Rezoning Transportation Analysis

Petition Number: 2023-124

From: Jake Carpenter, PE

Date	Description
11-21-23	First Review (IW)
12-19-23	Second Review (KC)
01-22-24	Third Review (IW)

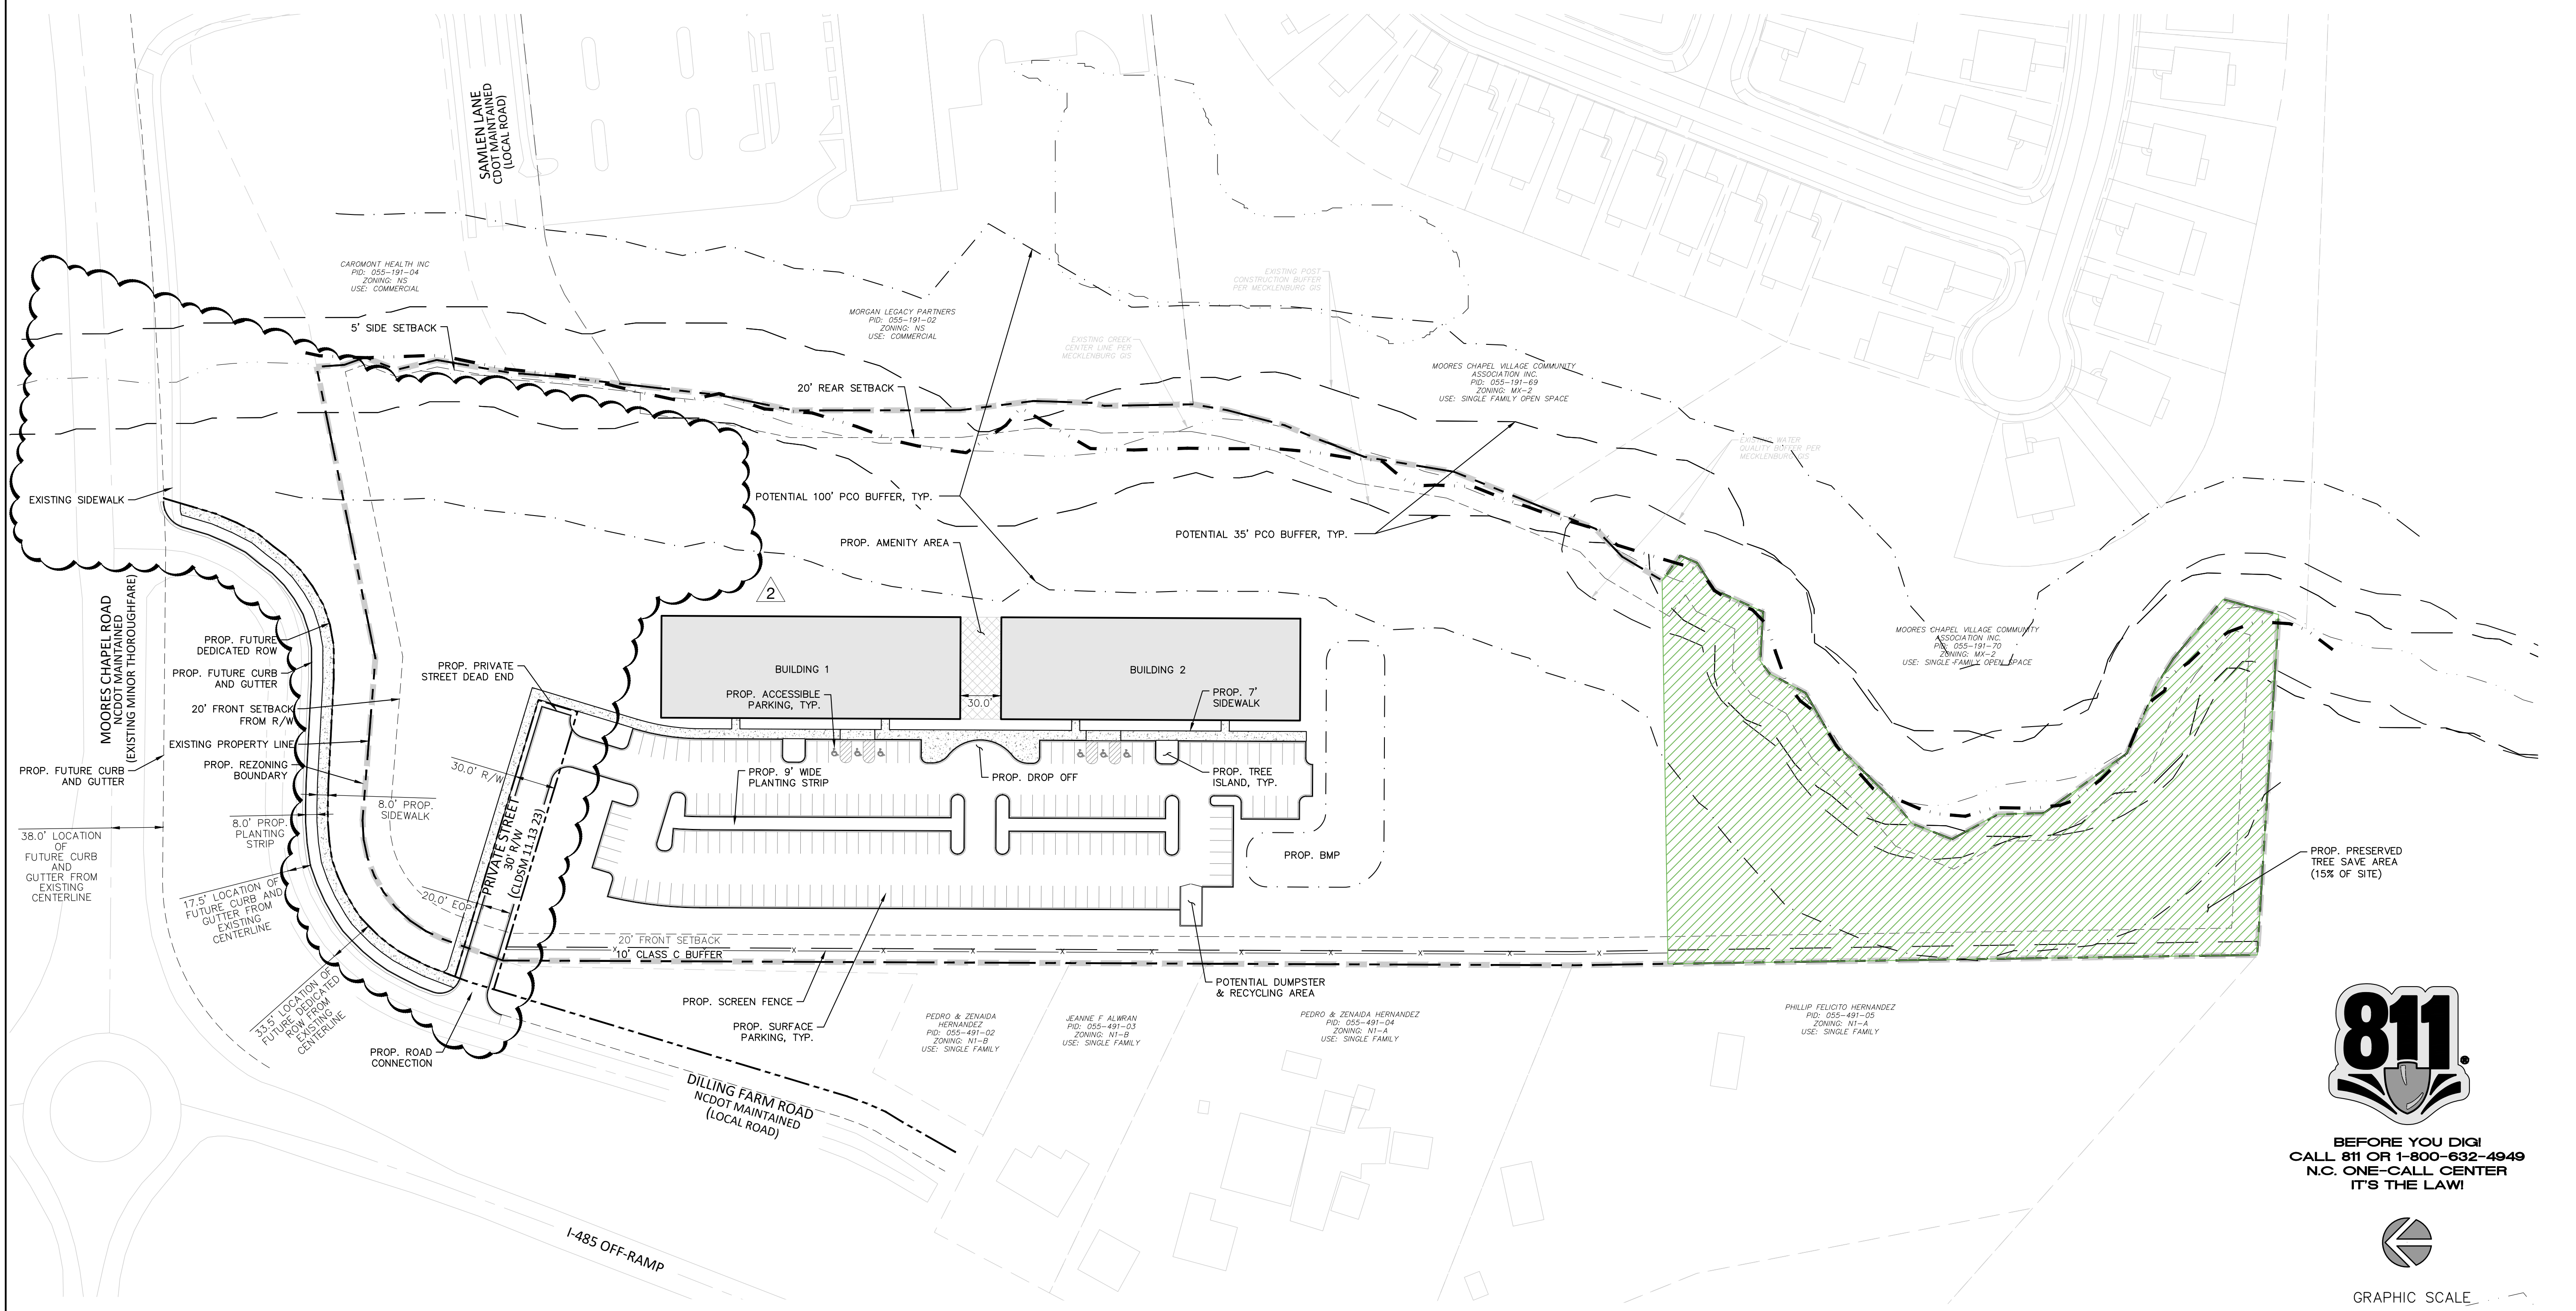
5. ~~Outstanding Comment 11-21-23: Revise site plan and conditional note(s) to commit to constructing an 8' planting strip and an 8' sidewalk per Article 33 of the UDO and CLDSM U-03A1 along Dilling Farm Road.~~

Clarifying Comment: Site plan does not show 8' planting strip and an 8' sidewalk per Article 33 of the UDO and CLDSM U-03A1 along Dilling Farm Road.
